In Matters Regarding Proposed Storage Units at 4909 Juan Tabo, by Guardian Storage & Extra Space Storage.

Case Number: PR-2019-002184 on 18December2019

FROM: Residents of Oso Grande (signatures are provided at the end of this letter.)
TO: Development Review Board

SHEET TITLE: CONCEPTUAL DRAINAGE PLAN

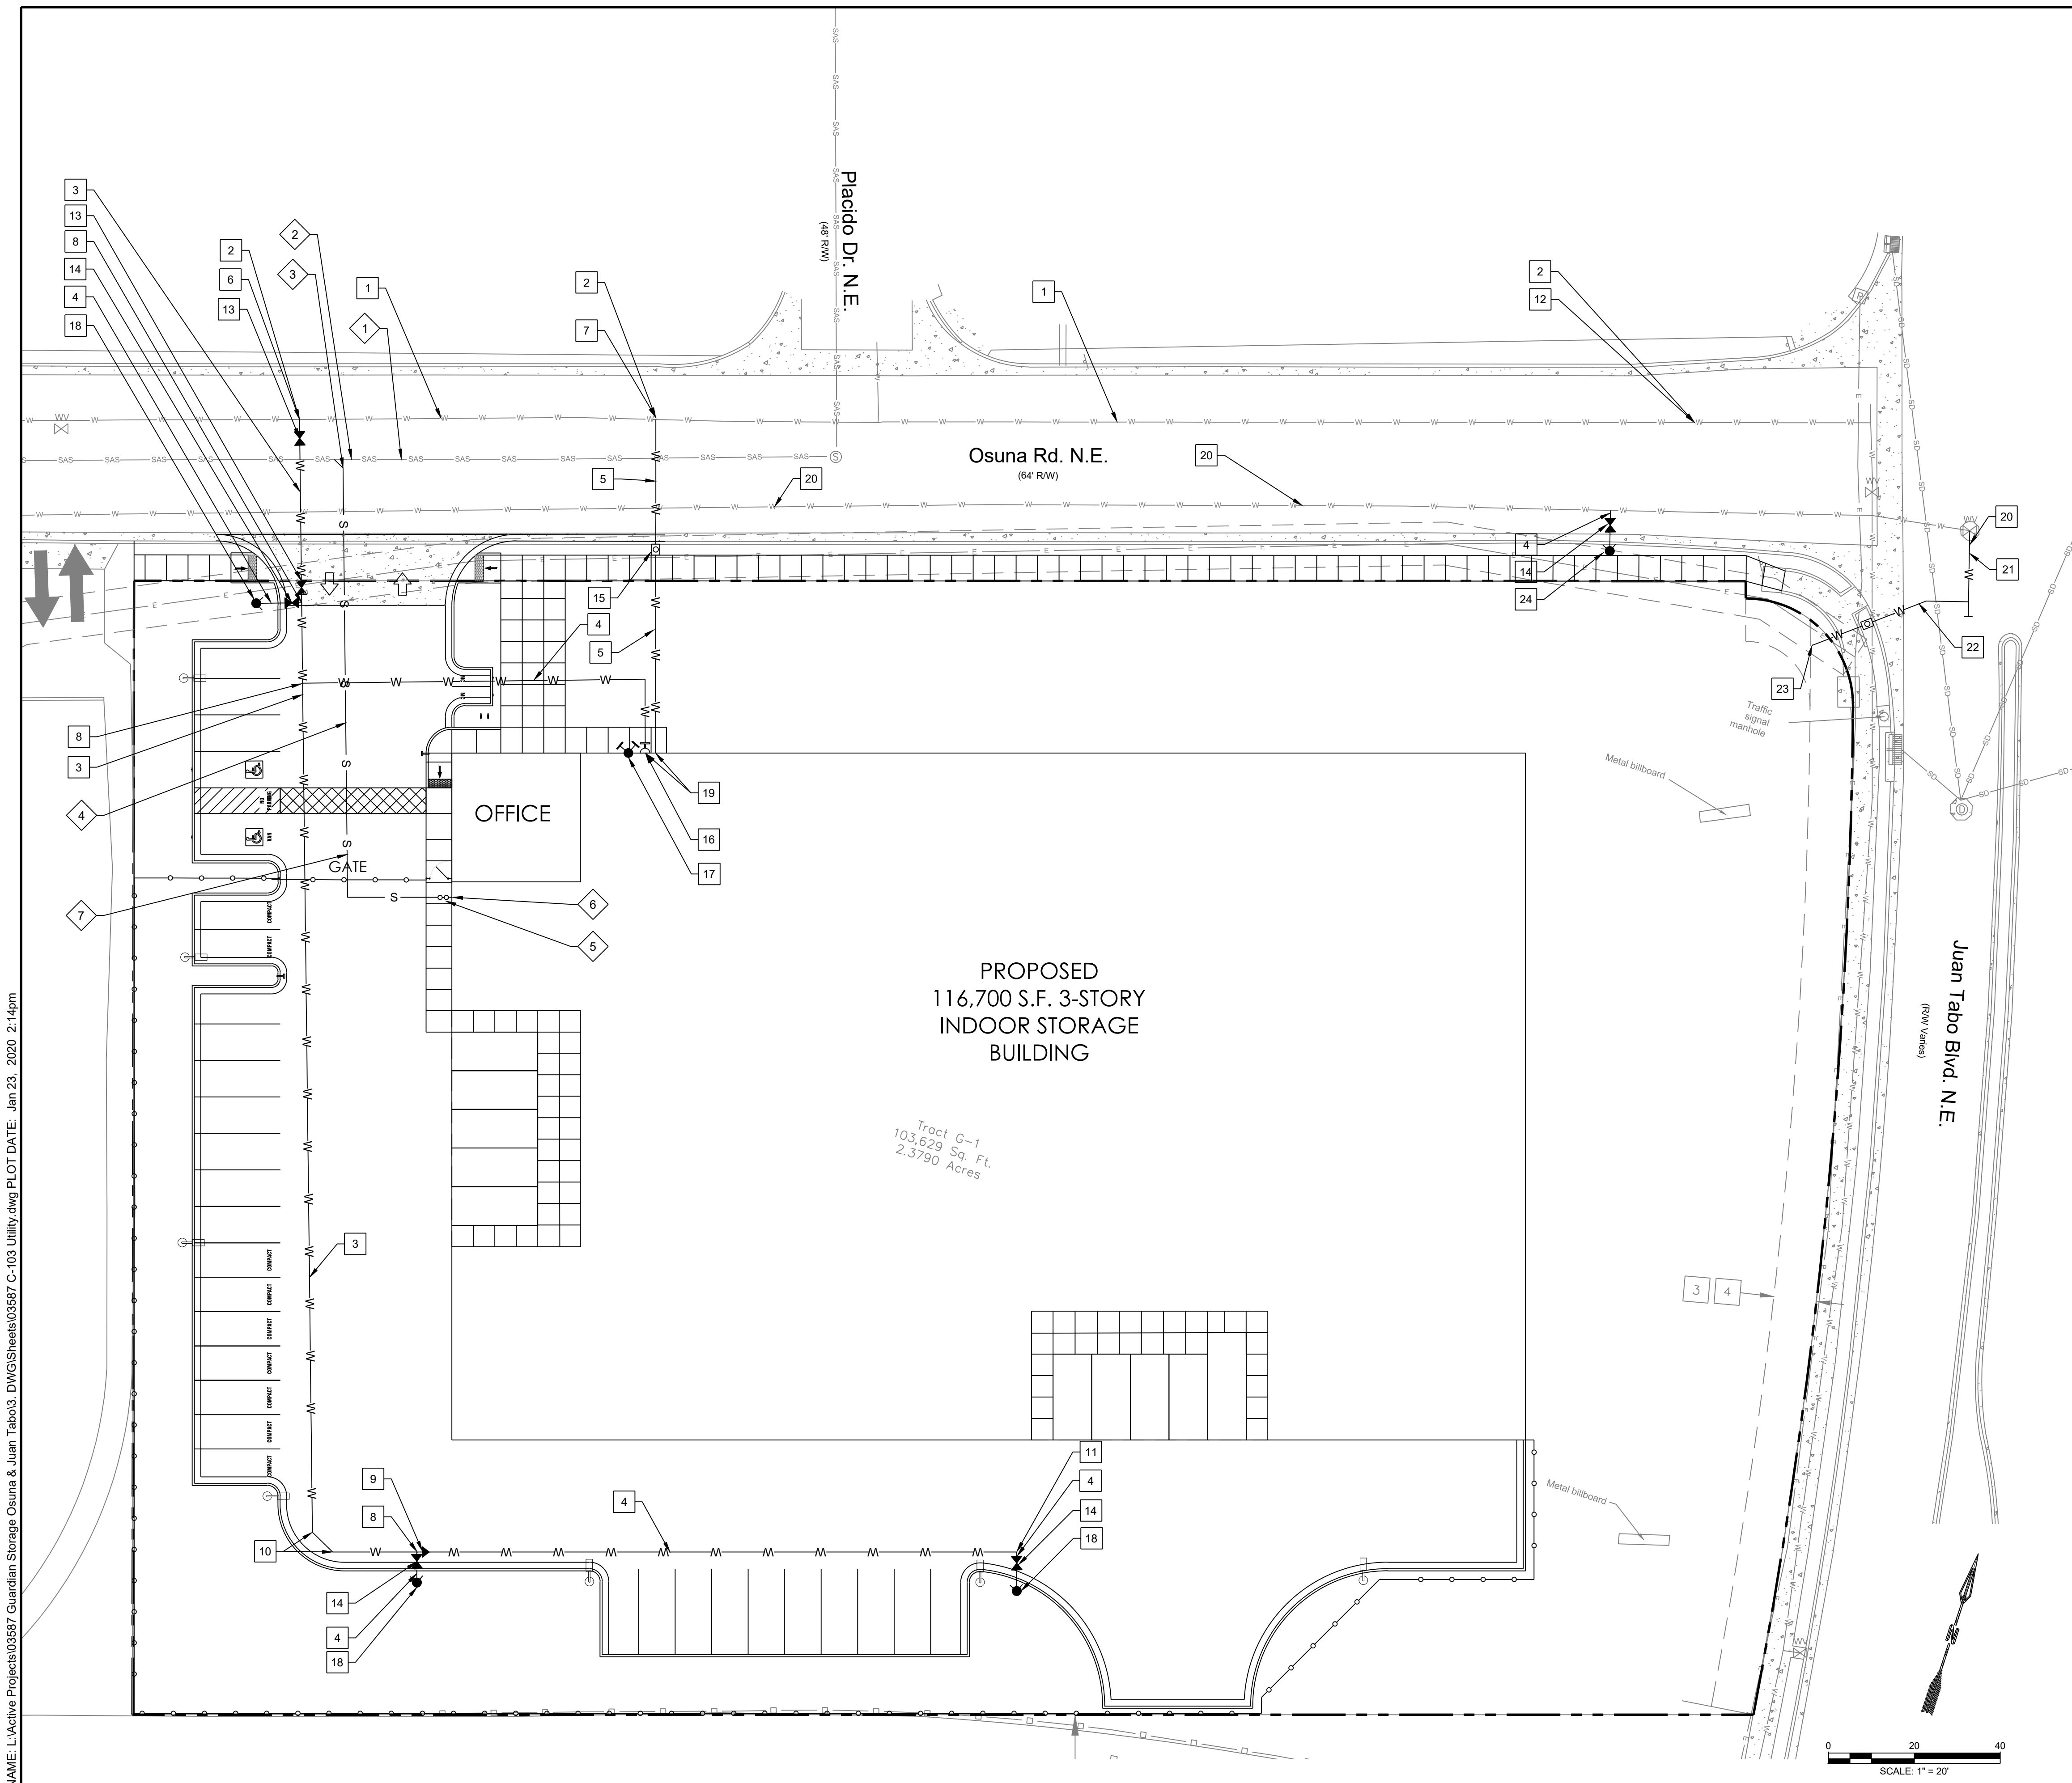
We are concerned residents in the neighborhood of El Oso Grande with homes located or near the floodplain downstream from the John B. Robert Dam. We are aware that the planned development on the floodplain identified as the 2.3 acre parcel, 4909 Juan Tabo is a FEMA defined floodway and FEMA defined flood prone area. The FEMA map dated 2008 indicates moderate risk to downstream residents. However, this map is extremely outdated. In our opinion, the 2008 map is likely underestimating the level of damage that could occur in the event of a significant flood.

Over the past two years, the floodplain located on the subject property has eroded and does not appear to be able to handle a significant flood. Any type of construction on this property will not only remove the capacity of the floodplain to appropriately function as its intended purpose resulting in increased flood waters downstream, but it will increase risks for loss of life and property.
